Y/10/22/PL

Land to the south of Ford Lane and east of North End Road Yapton BN18 0DS

Erection of 15 No dwellings (including 4 No affordable units) with associated access, parking, landscaping, drainage and public open space (additional units to those approved under application Y/123/21/PL). This application may affect the setting of a listed building, affects the character & appearance of the Church Lane Conservation area, affects a Public Right of Way and is in CIL Zone 2 and is CIL Liable as new dwellings.

Title:
OCCUPANCY PLAN

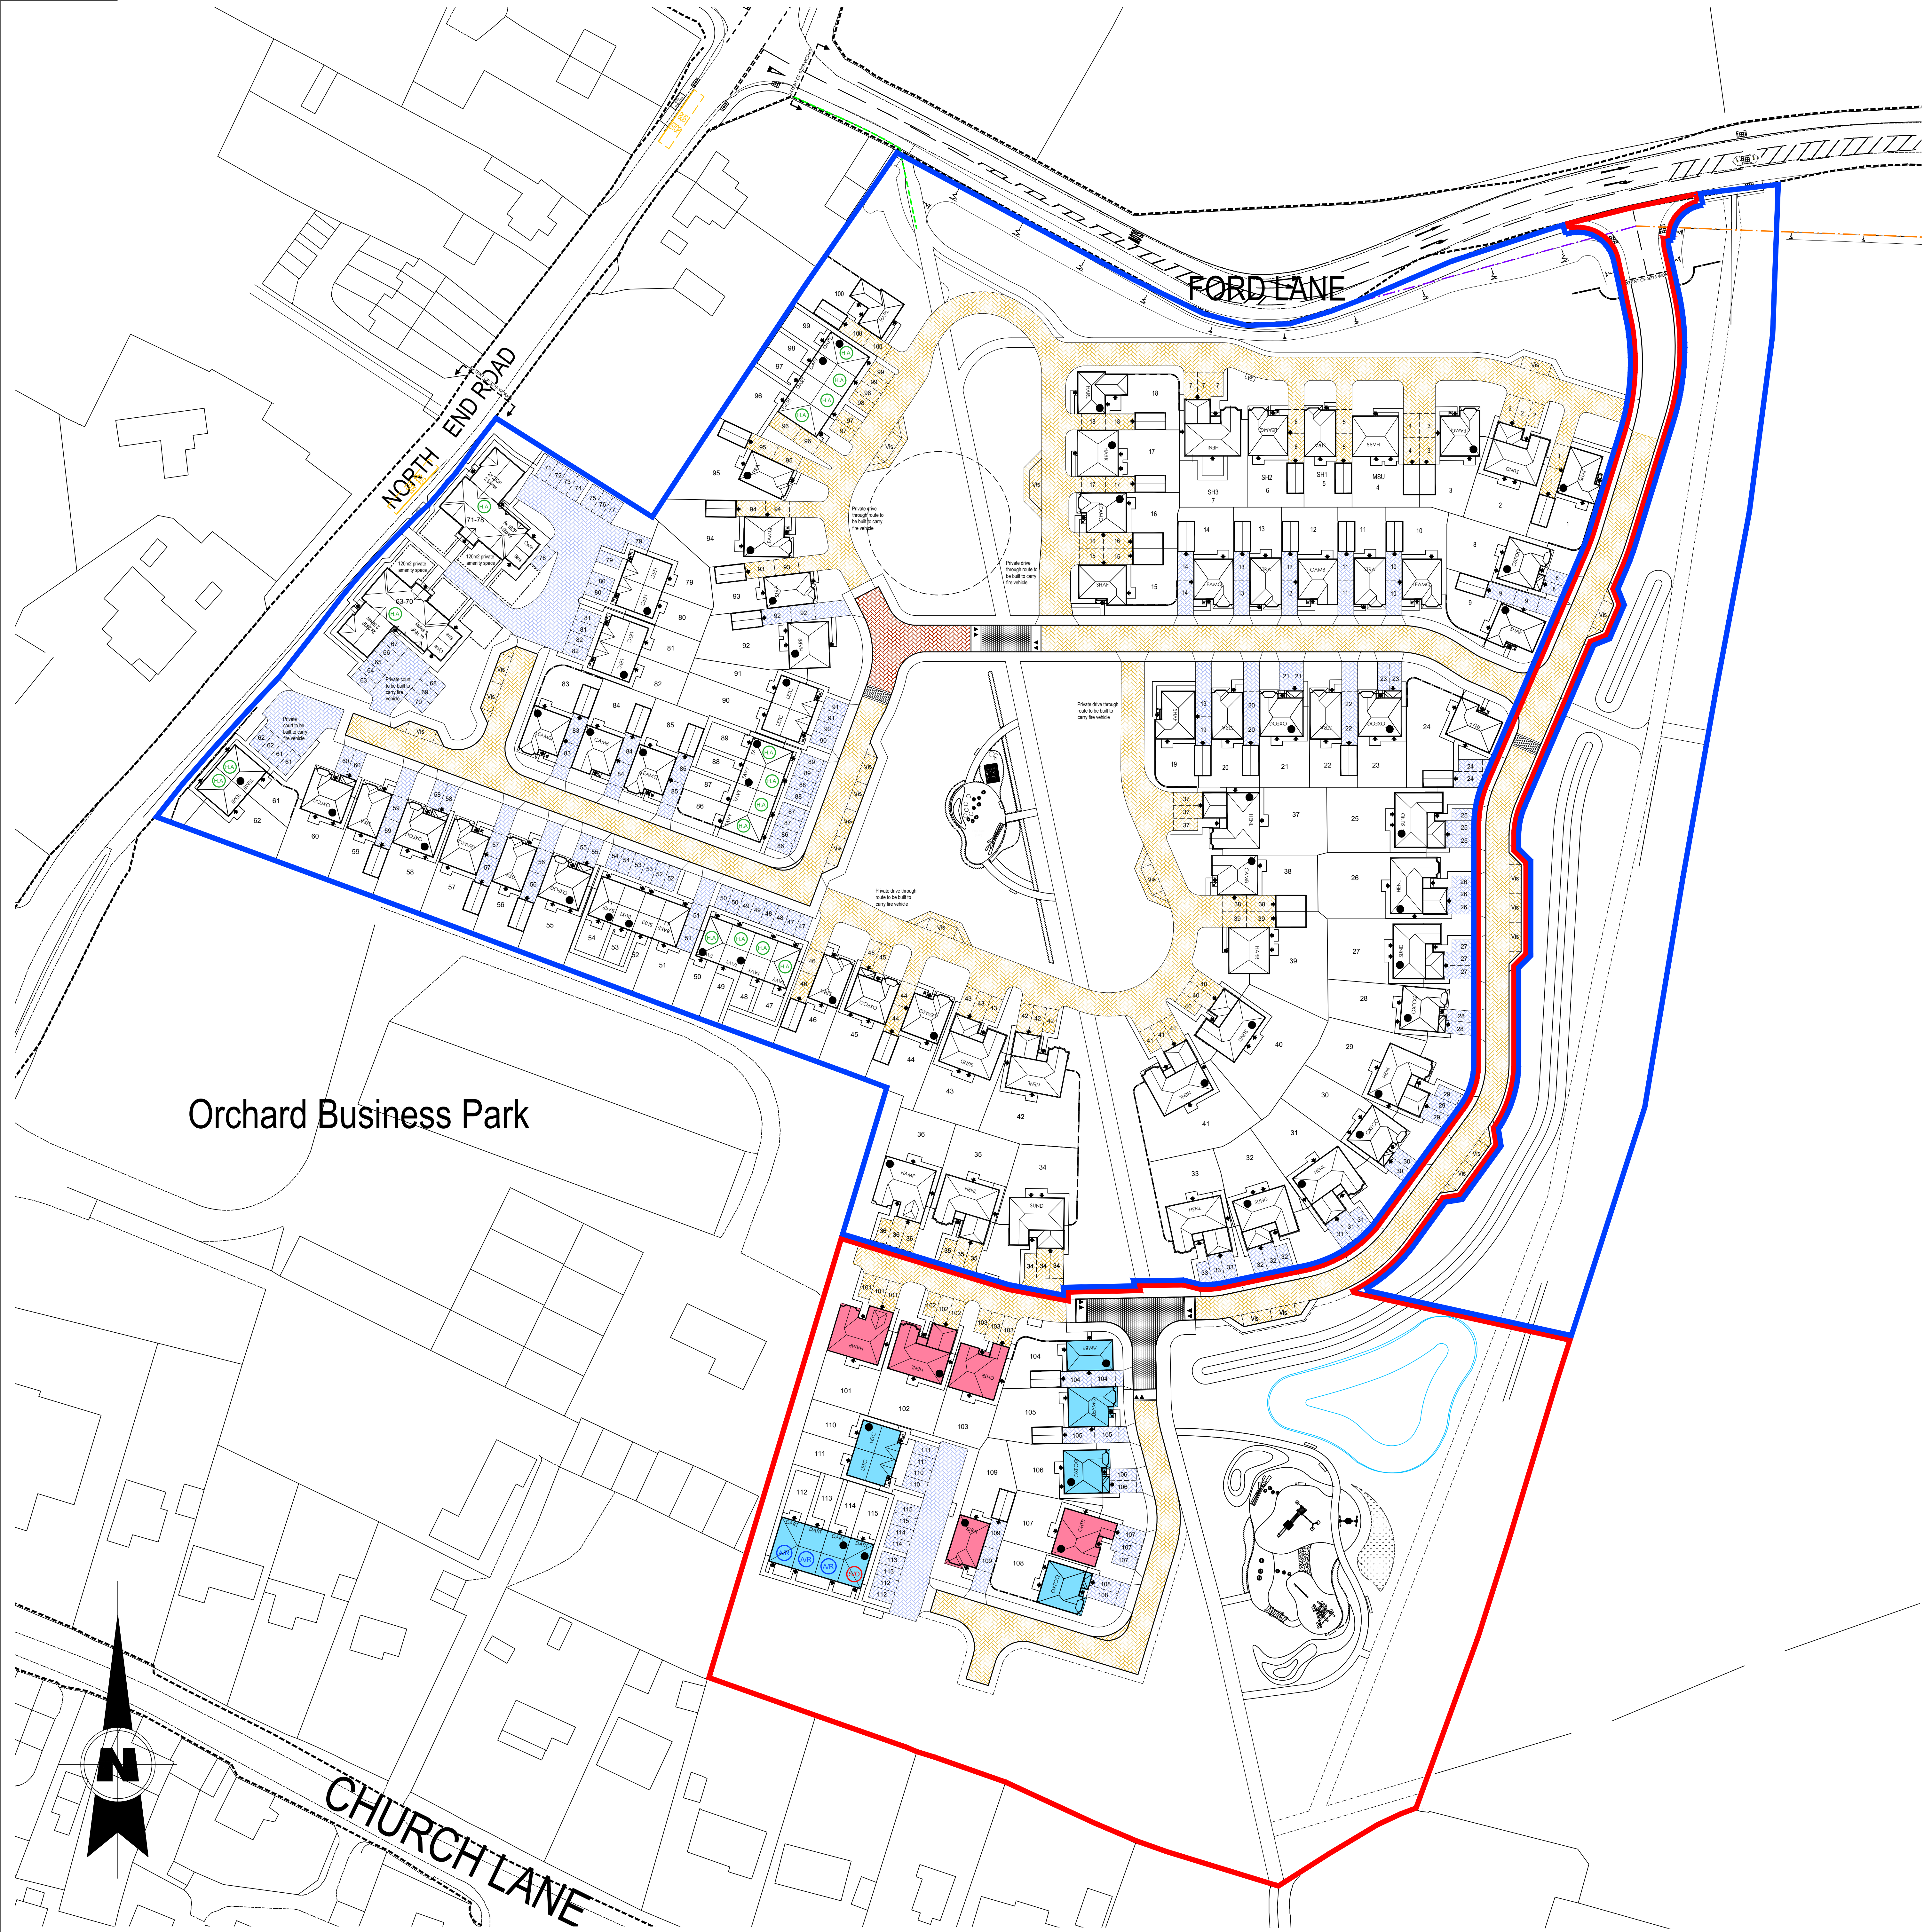
The proposal is for the erection of an additional 15 dwellings in part of the area identified as open space to the south of the existing area of new housing.

The proposal to develop this part of the open space (which was to be provided as part of the larger housing estate), represents an intrusion into *this significant physical and visual buffer* between the housing and the conservation area. The current proposal would reduce this open space so that the buffer area between the conservation area and the main part of the development is much smaller with development much closer to the conservation area. It would also negatively impact upon the pleasant transition area between the conservation area and the main part of the development. Such an approach would appear to be in conflict with the original aspirations of the design of the development. I note that a large portion of the reduced green space would be used as a play area or a pond, which would greatly reduce the area left for informal landscaping. The result is that the proposed development will negatively affect this part of the setting of the conservation area.

Leamington
Lifestyle

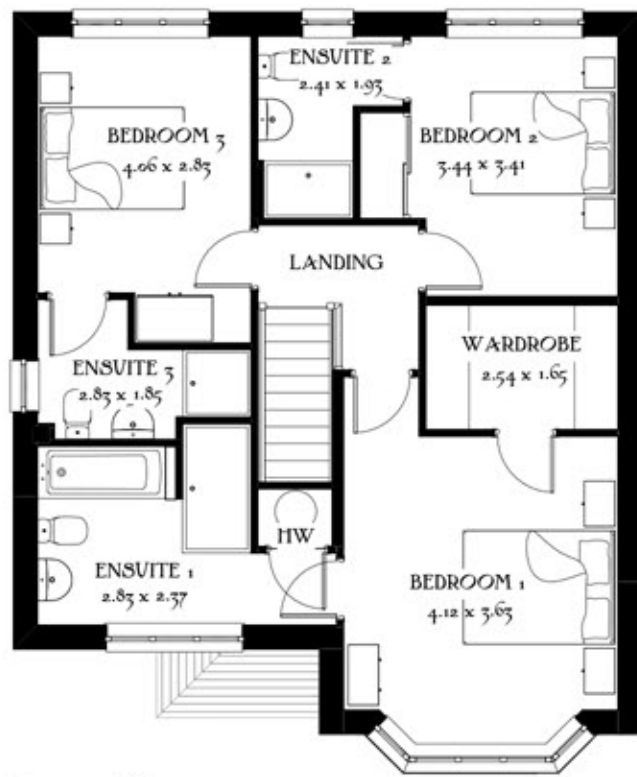
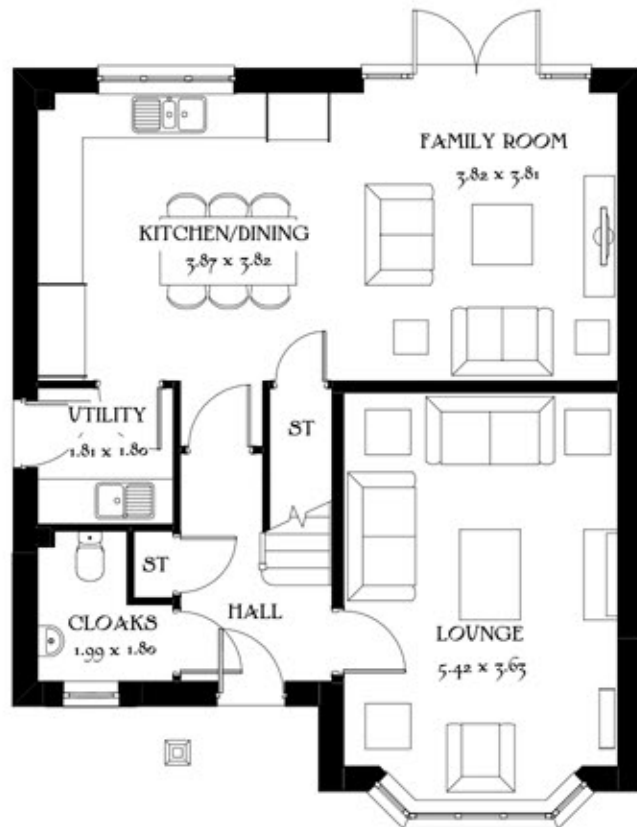
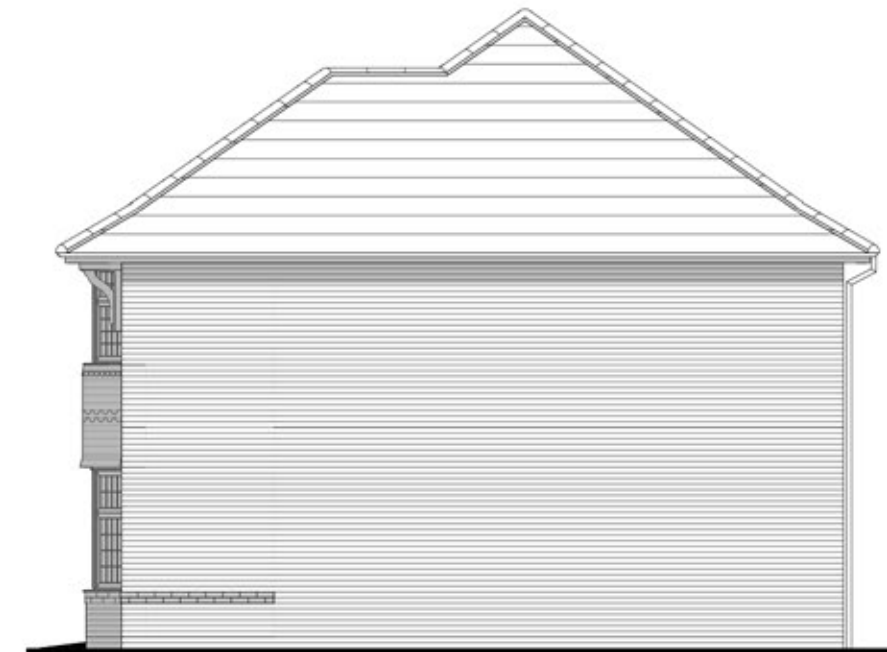
Whilst the design of the houses appear to be based on the designs of properties constructed in the early to mid C20, they are now more of a standard design found in many different parts of the district. Their individual qualities no longer apply to this location. I previously identified that the success of such designs will ultimately depend upon the quality of the materials proposed, which should be carefully considered. However, it appears as if standard machine made materials are to be used, which is also disappointing and not fully appropriate given the proximity to the heritage assets. Other developers in the local area have provided improved materials for those buildings closest to identified heritage assets.
